**SSD-76927247 – The Timberyards by RTL Co. (Project) - Objection**

**Re: Objection to SSD-76927247 - The Timberyards by RTL Co.  
Victoria Road, Sydenham Road, Farr Street and Mitchell Street, Marrickville**

### 1.0 Introduction

### Shadow Diagram

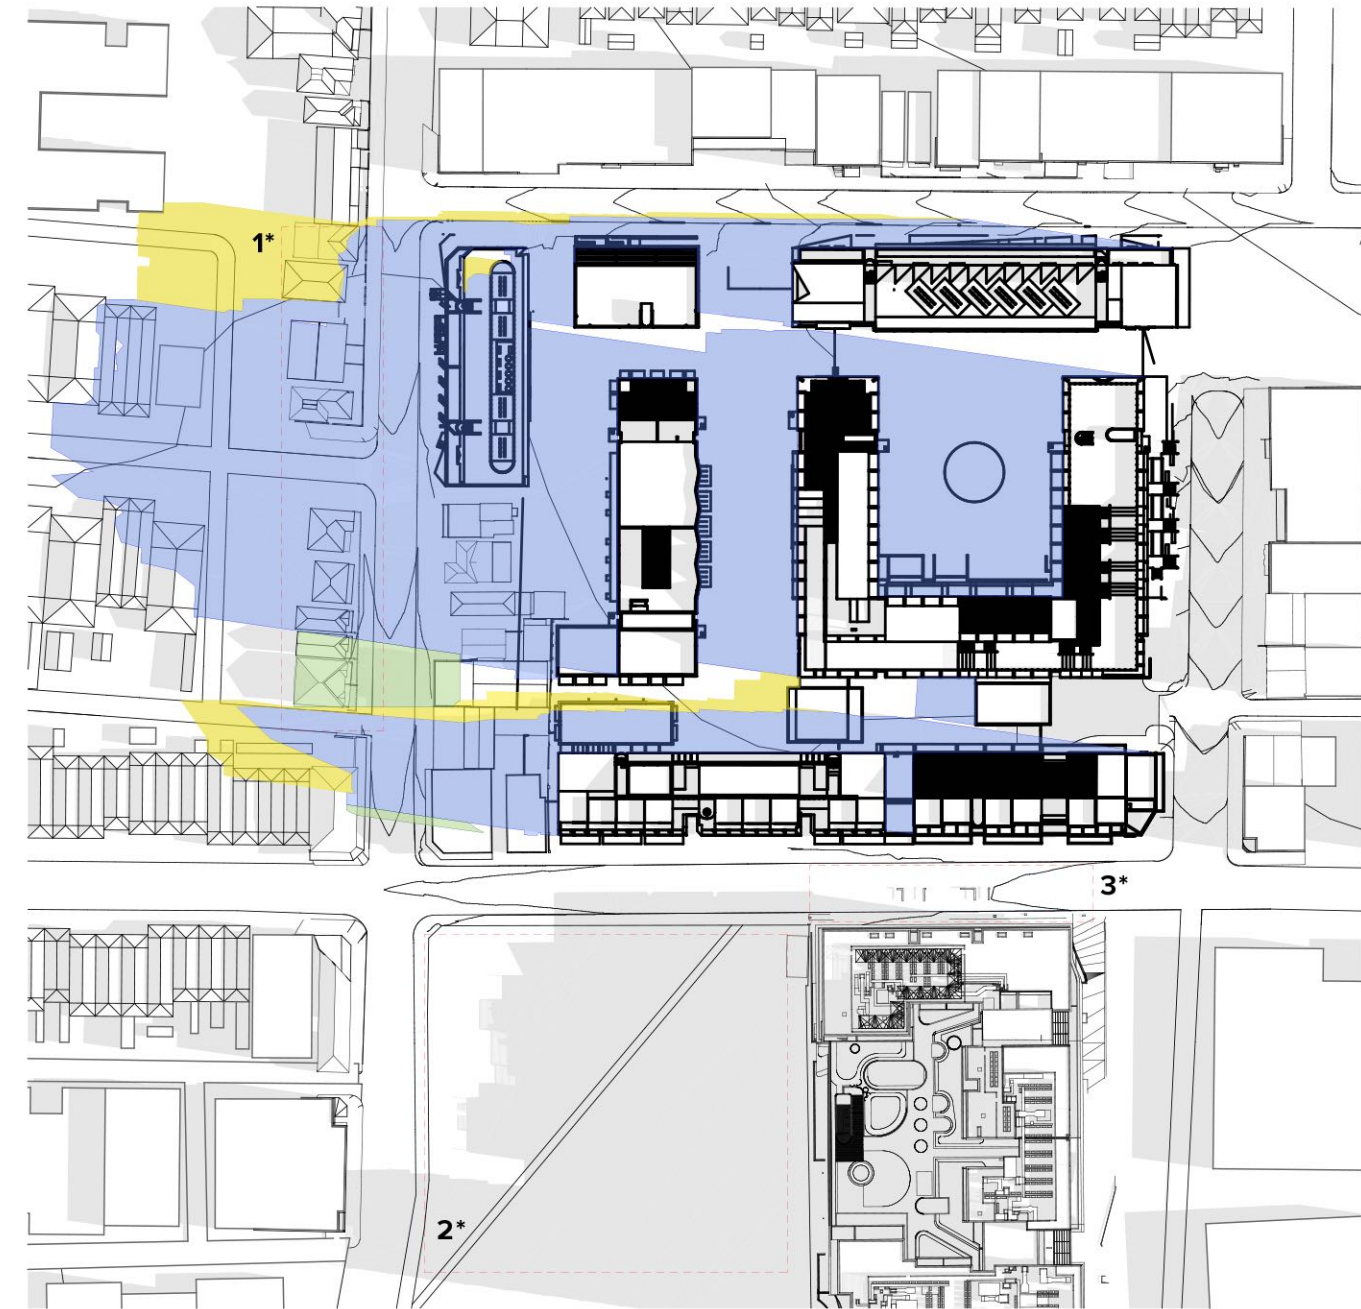
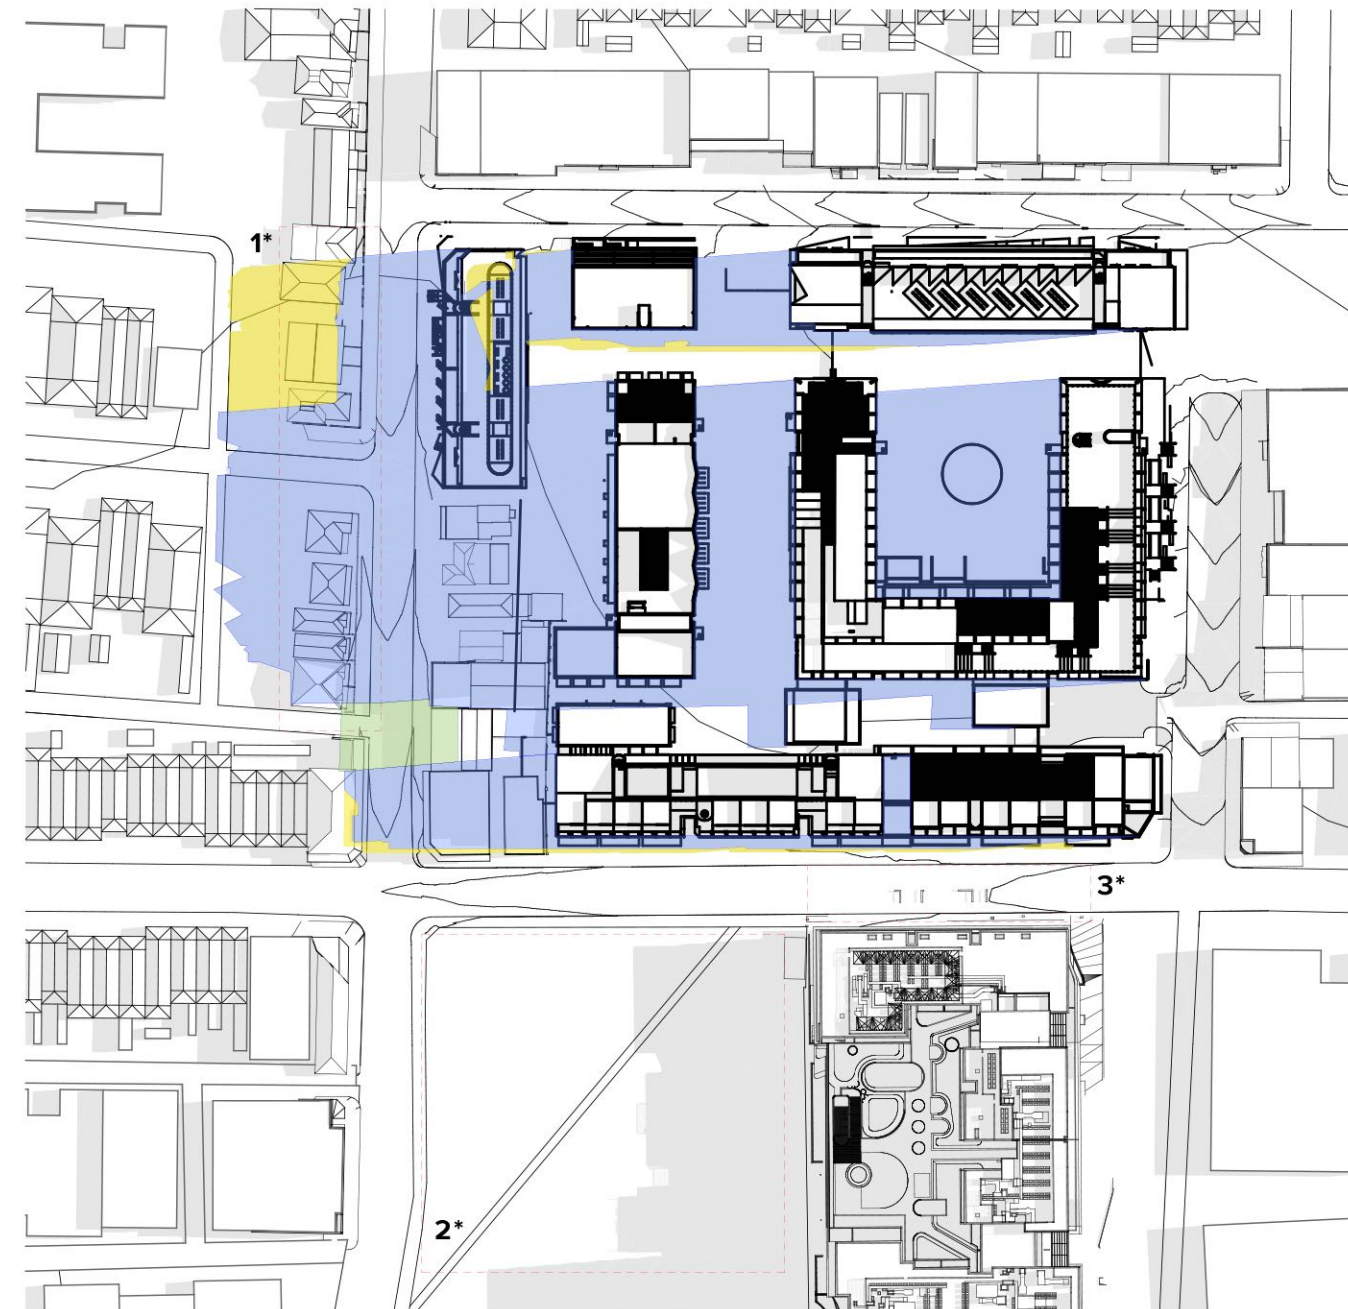
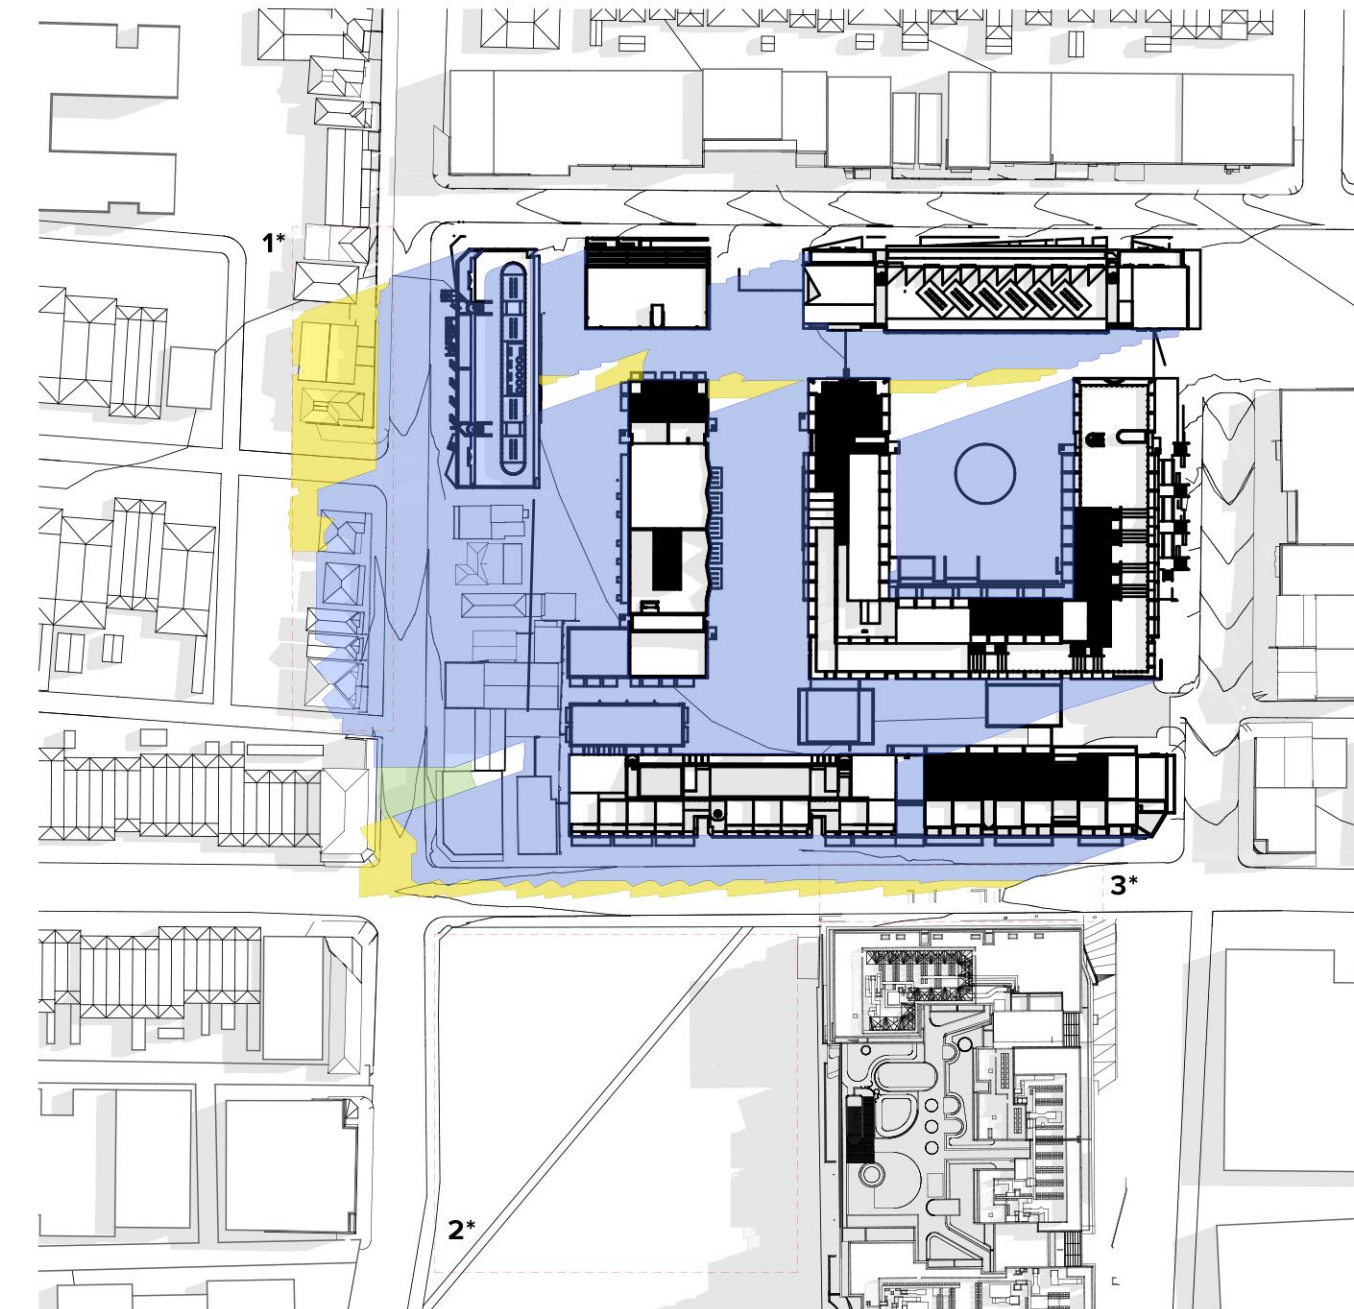
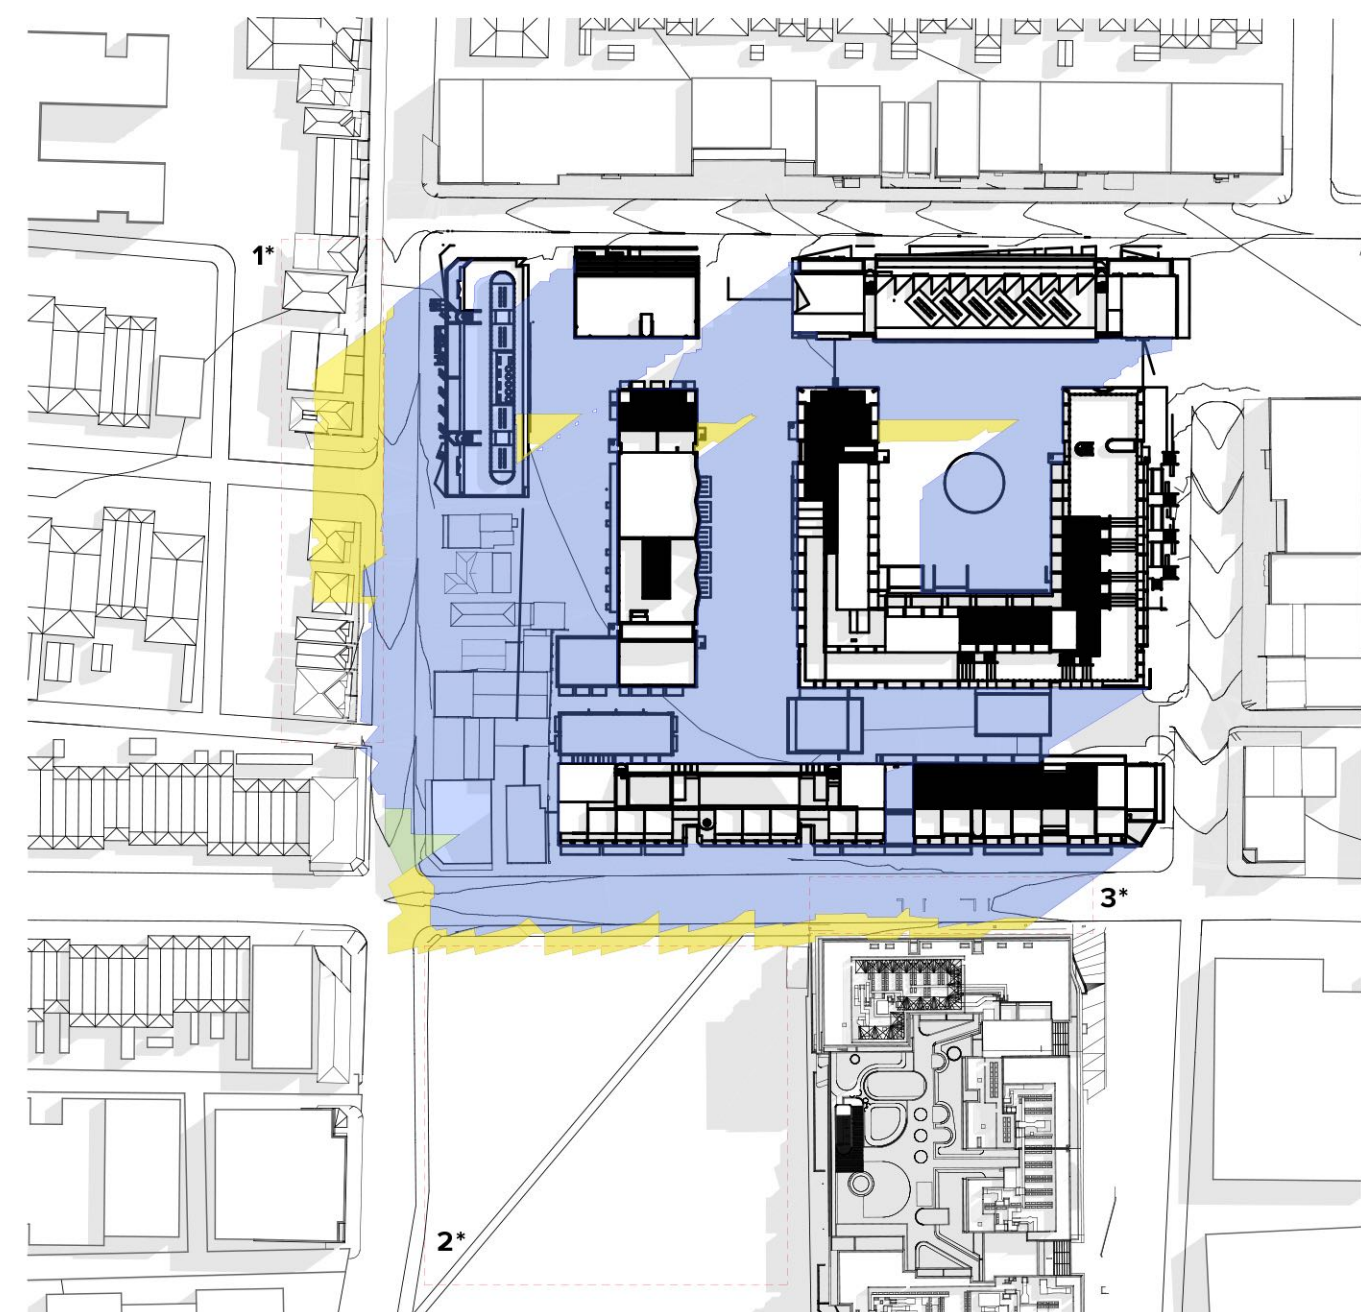
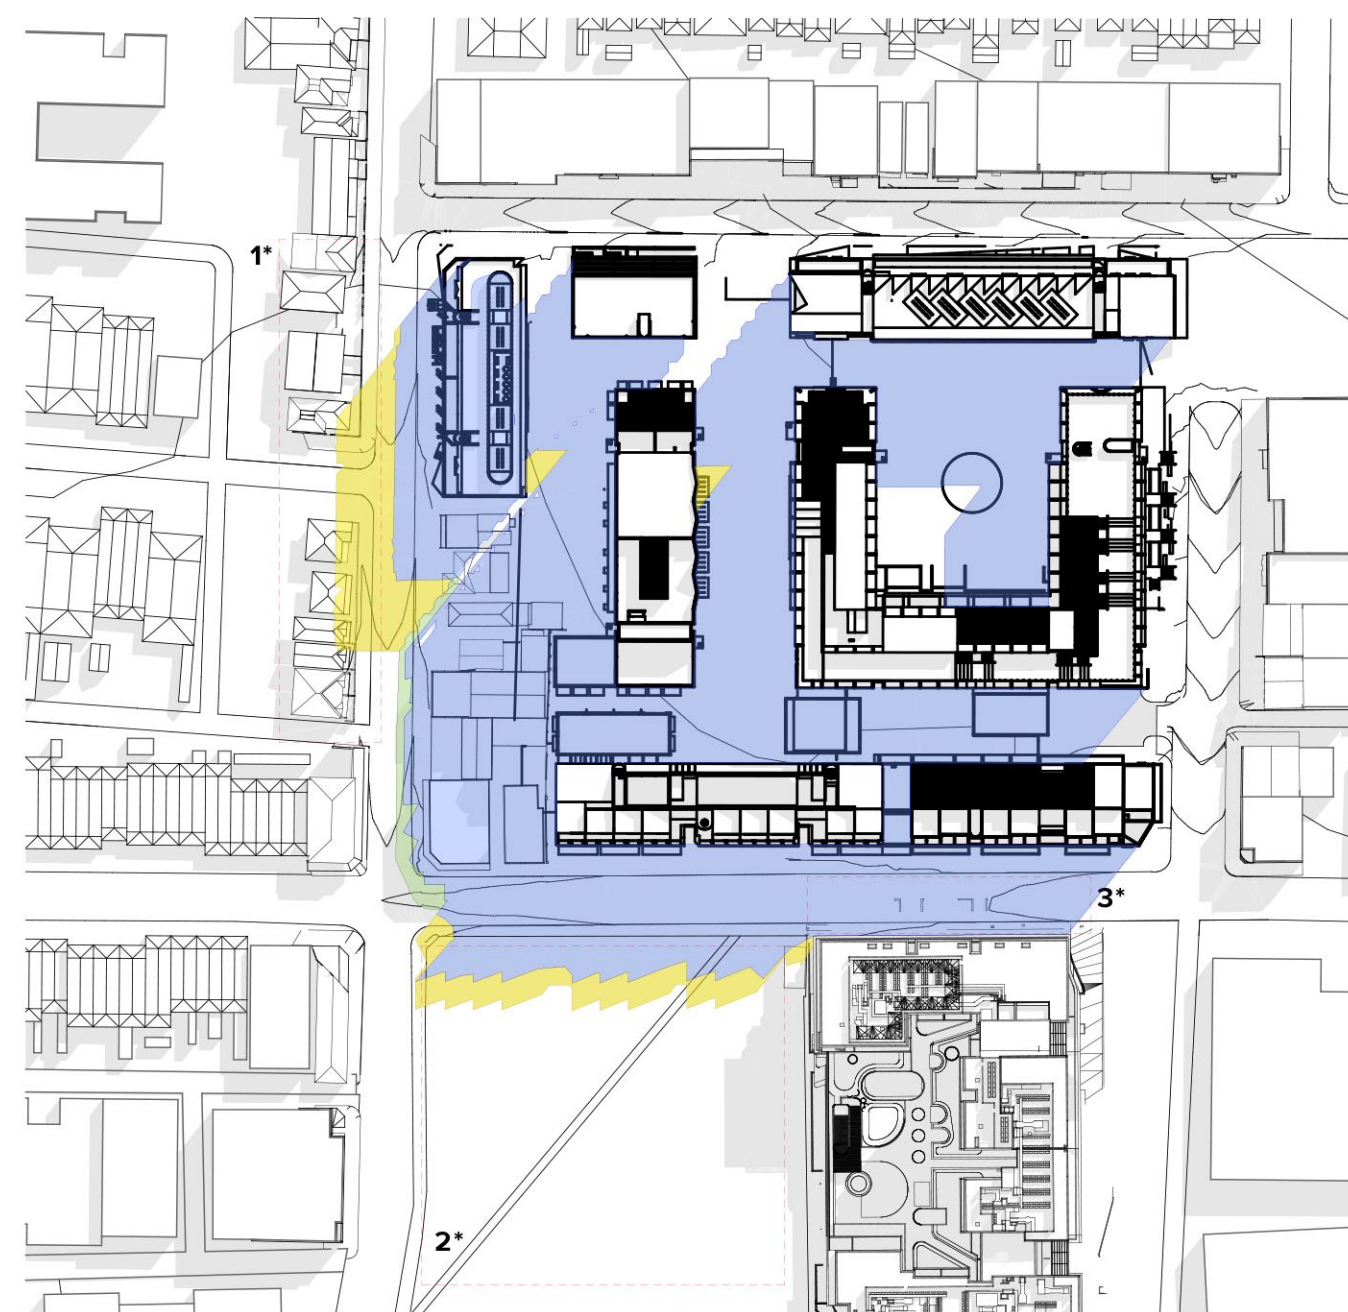
However, the information submitted with the DA does not include any analysis of the impact of overshadowing of the proposed development, especially Building E, on the northern façade of a future building on our Clients' Land or other land in the Corner Site.

Our assessment is that Building E will completely block sun to a future building on our Clients' Land between 9am and 2pm at midwinter and almost completely block direct solar access to any building on the Corner Site.

This can be seen from the extracts from the shadow diagrams from the DA documentation at **Figure 4** below.
